SLAF
C/O Suffolk Highways

Your Ref: EN010012
Our Ref: Registration ID 20026008

Representation to the Planning Inspectorate by the Suffolk Local Access Forum in response to the Development Consent Order by NNB Generation Company (SZC) for the proposed Sizewell C Nuclear Power Station. Planning Inspectorate Reference: EN010012

DRAWING TITLE:
 CONSTRUCTION PHASE

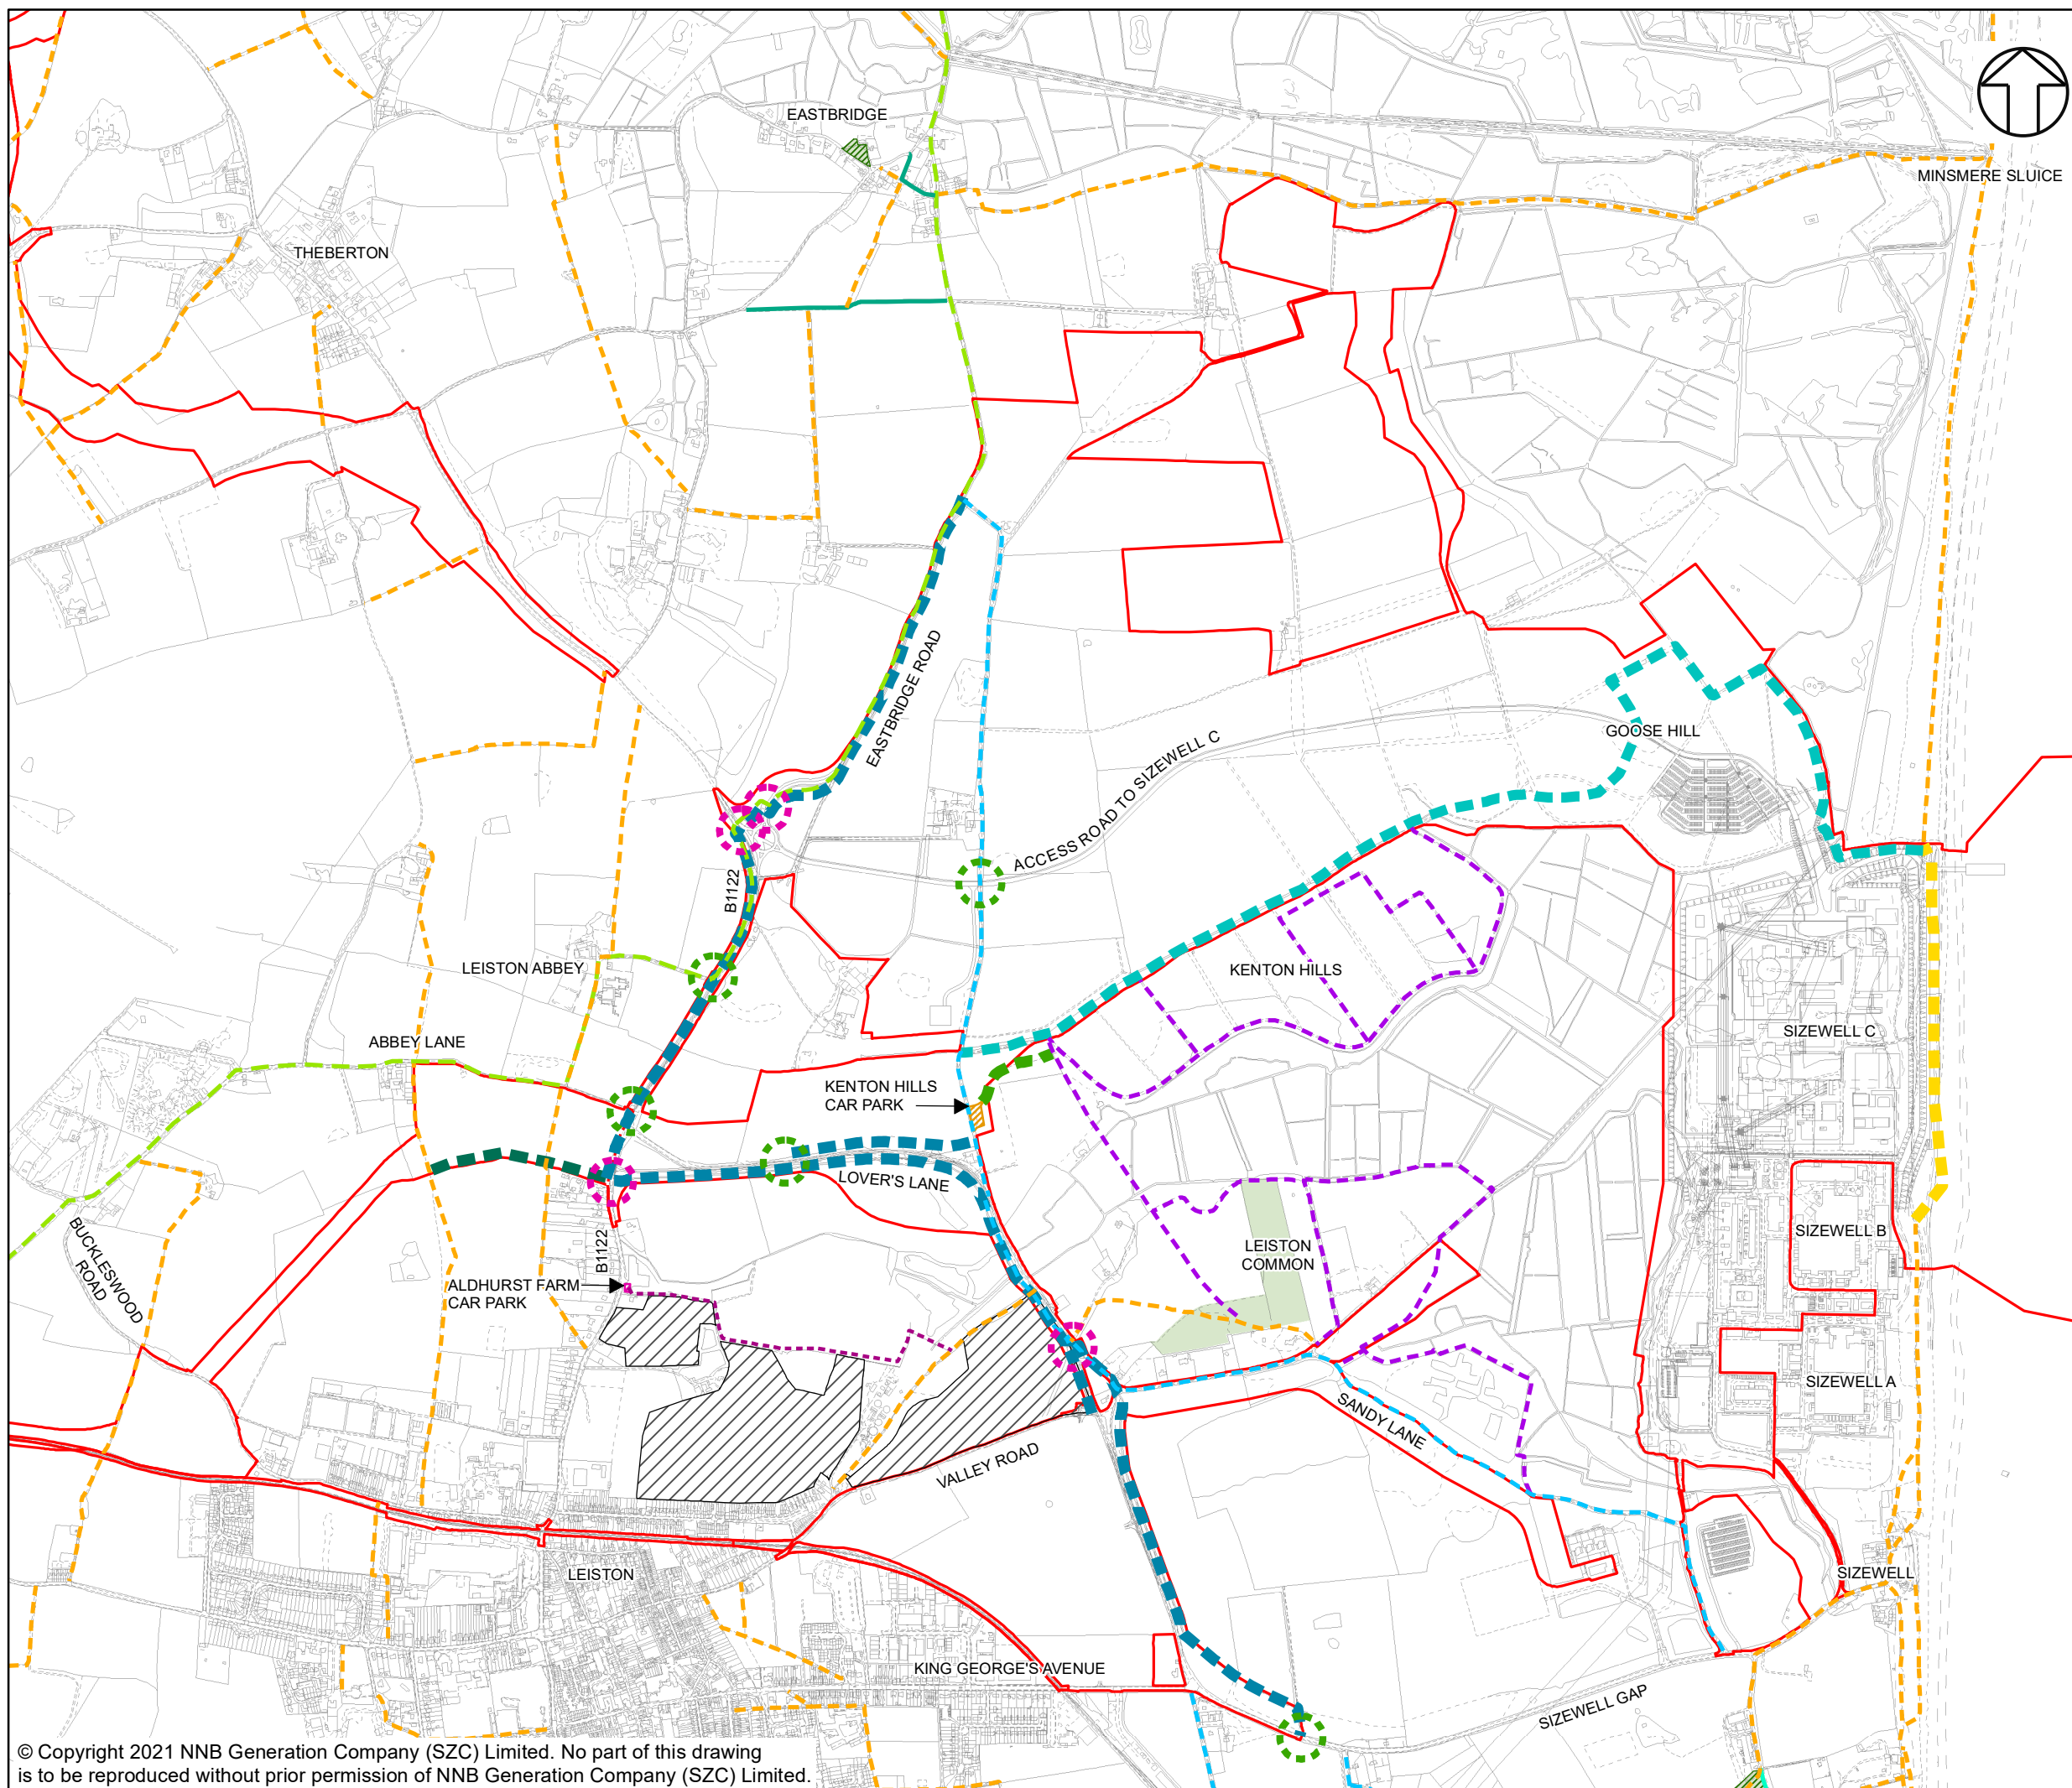
With regard to the local rights of way network SLAF has accepted the loss of Bridleway 19 during the construction period and welcomed the provision of an off-road route adjacent to the Eastbridge Road but would ask that this route is continued to Eastbridge itself. We would also ask for a safe pedestrian link from the B1122 through Aldhurst Farm to meet with Sandy Lane.

As you are well aware, the role of SLAF is to advise the local highway authority and other organisations on access issues and that has been our focus during each stage of consultation. We welcome the amendments proposed to the proposed Bridleway19 diversion which will be used during the construction phase, particularly the reduction in road crossing points, the split surface shared route for equestrians, pedestrians and cyclists, also the new link to the proposed worker's caravan site. However, we would like to see the off-road bridleway route to be extended further north towards Eastbridge itself before it meets Eastbridge Road. The safe crossing points to be constructed as part of the Bridleway19 should be retained post construction.

DRAWING TITLE:
 OPERATIONAL PHASE

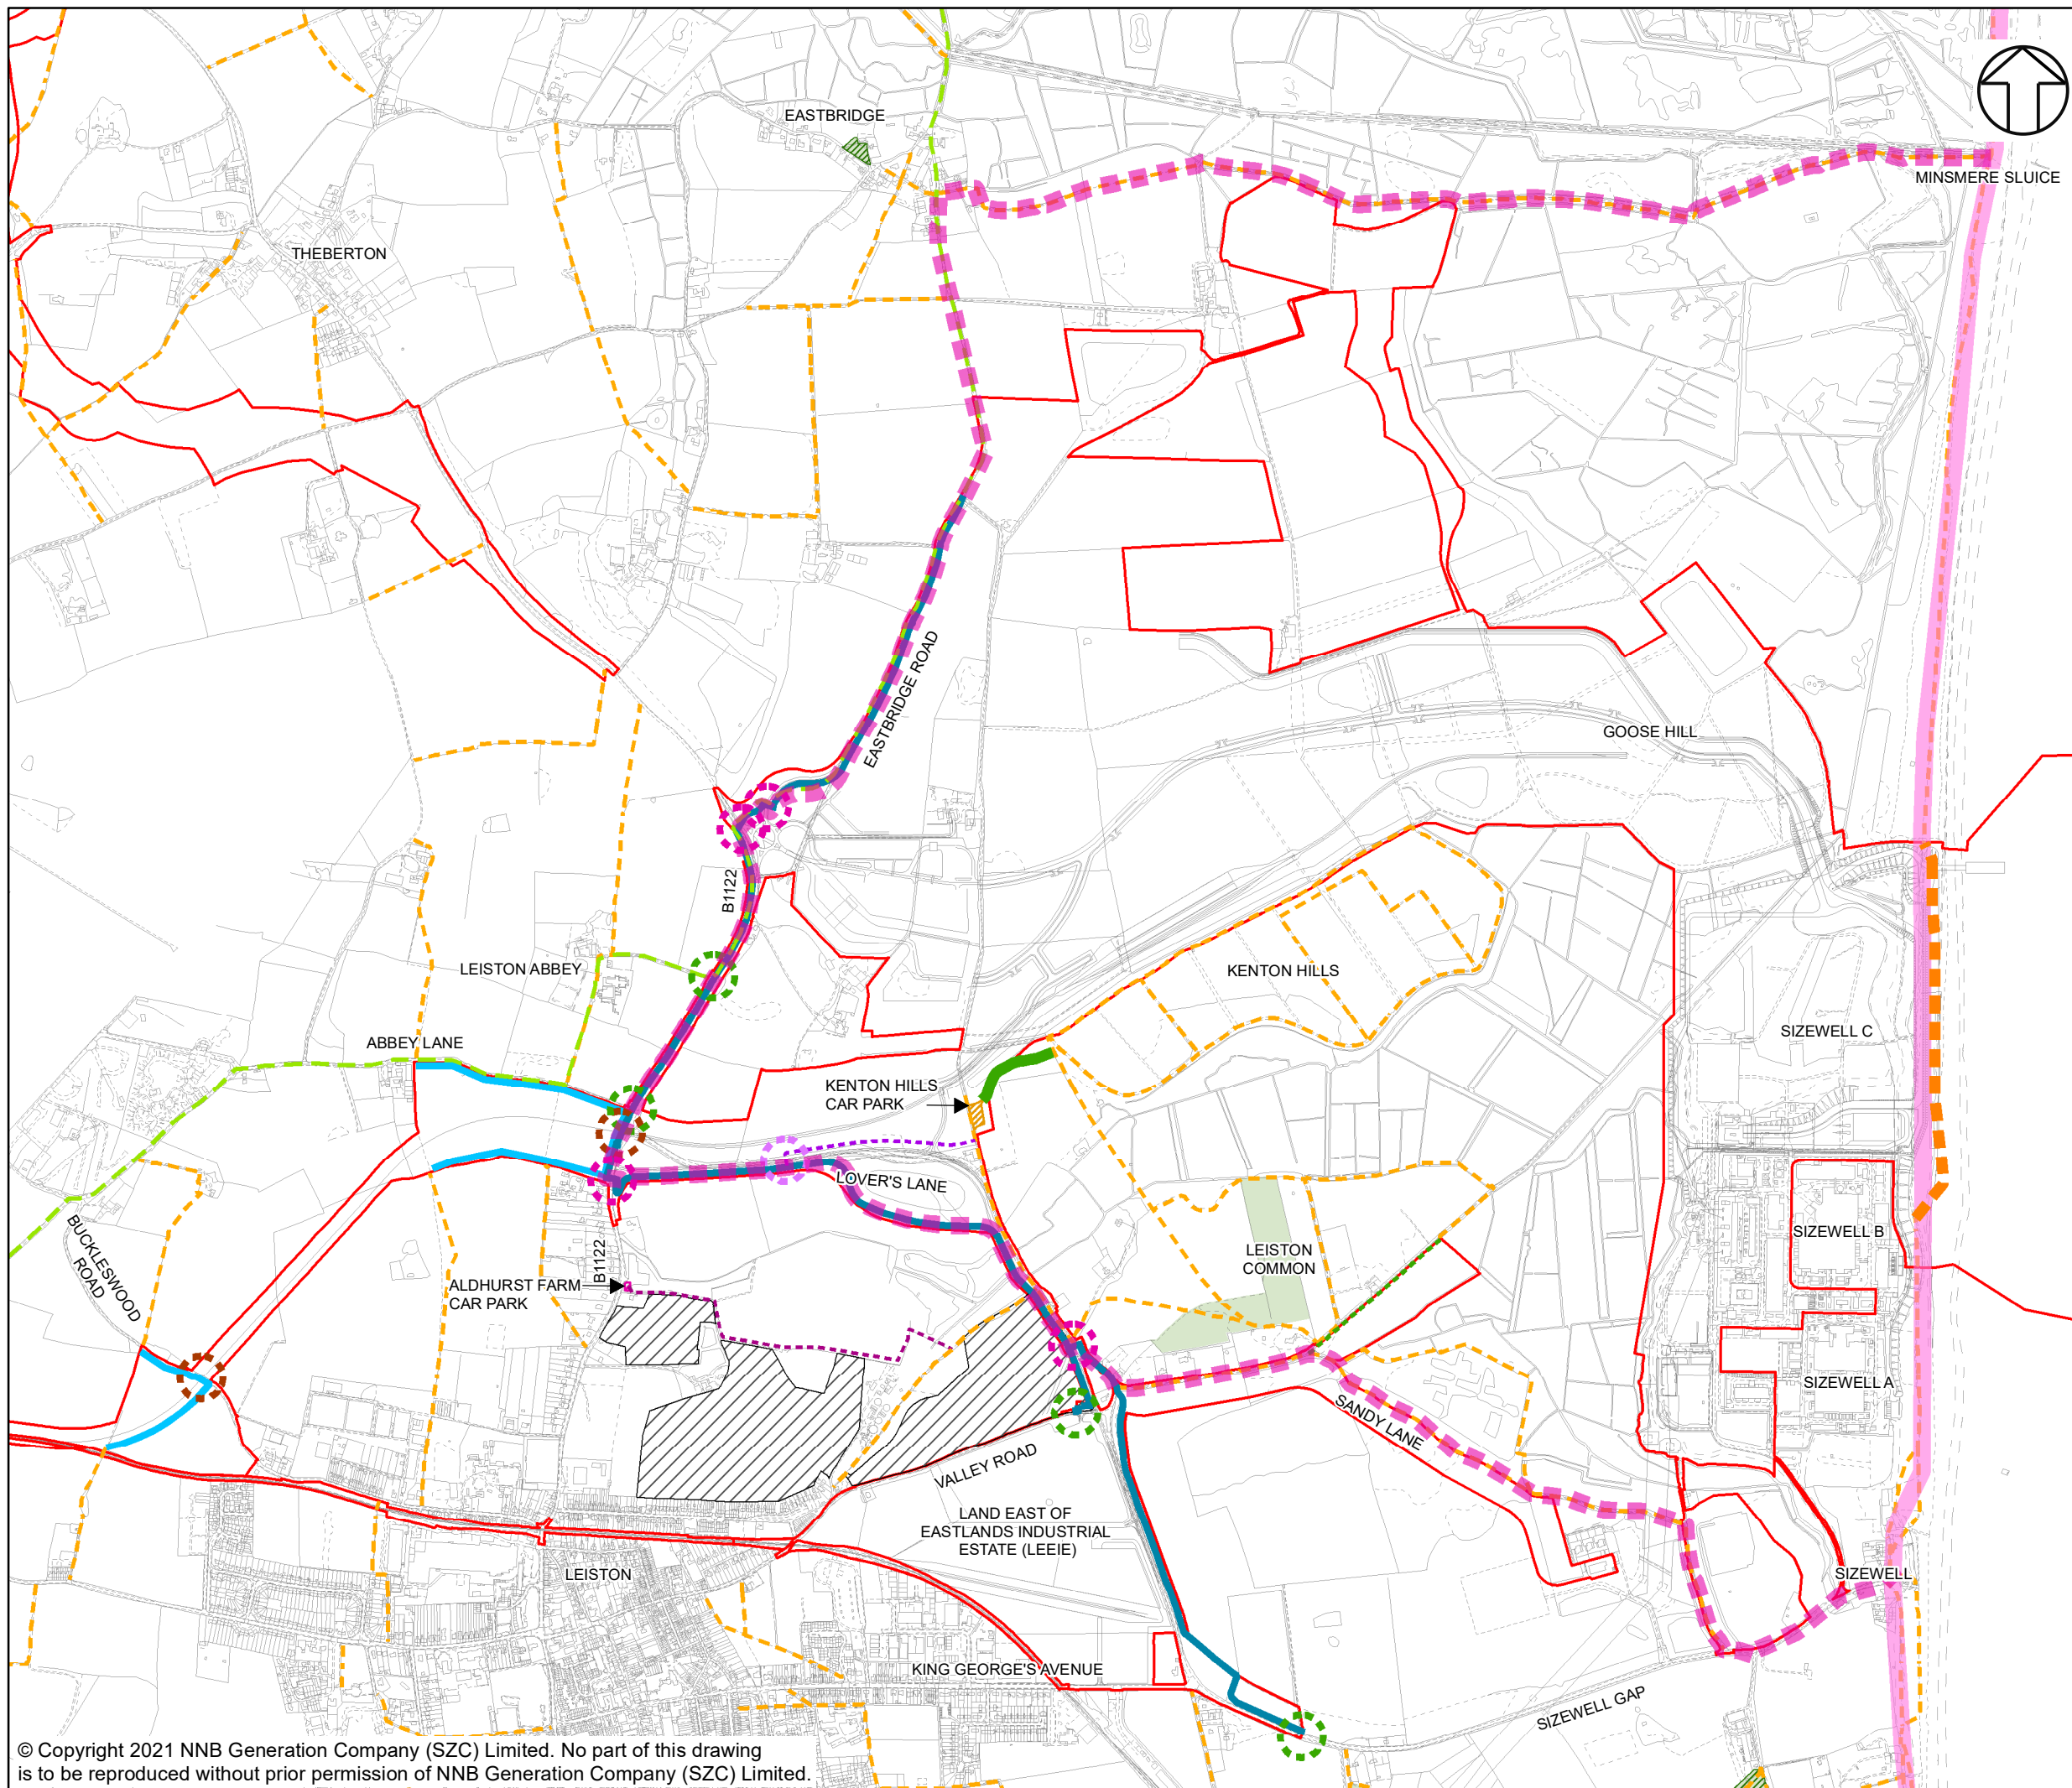
Post construction, SLAF are requesting that there should be a significant legacy benefit to the public access to the wider area around the power station including the permissive routes around Kenton Hills becoming definitive, with a new link to the coast path and better off-road cycle routes between Aldeburgh and Southwold.

At Kenton Hills, whilst we welcome the new connection route to the permissive path network we would like to see post construction the link between Bridleway19 and the Coast Path become a definitive route as part of the legacy.
